RE: Existing Septic System Inspection BRES# 1810-0040

An attempt was made to evaluate your property for the purpose of issuing an Existing Tank Permit. The evaluation could not be completed for one or more of the following reasons.

Harnett County Department of Public Health Site Sketch

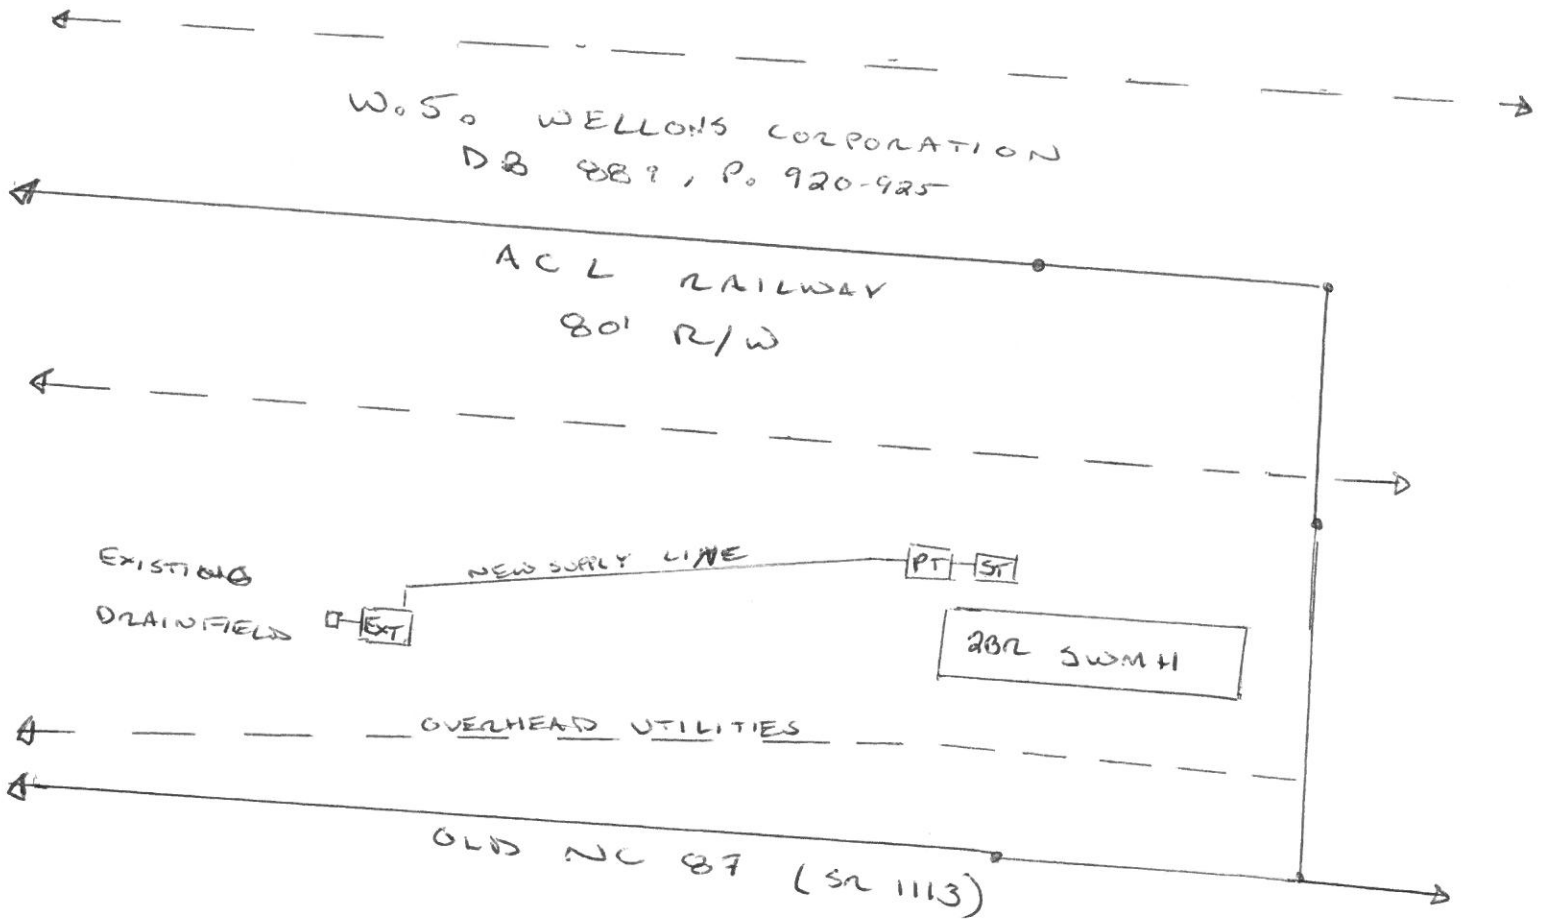
4. Other - Outlet end of septic tank shall be uncovered (inlet in uncovered). Revisit fee required. SWMH located downhill from existing tank. New septic tank and pump tank will be required to pump to existing system. Former SWMH was located up by existing tank.
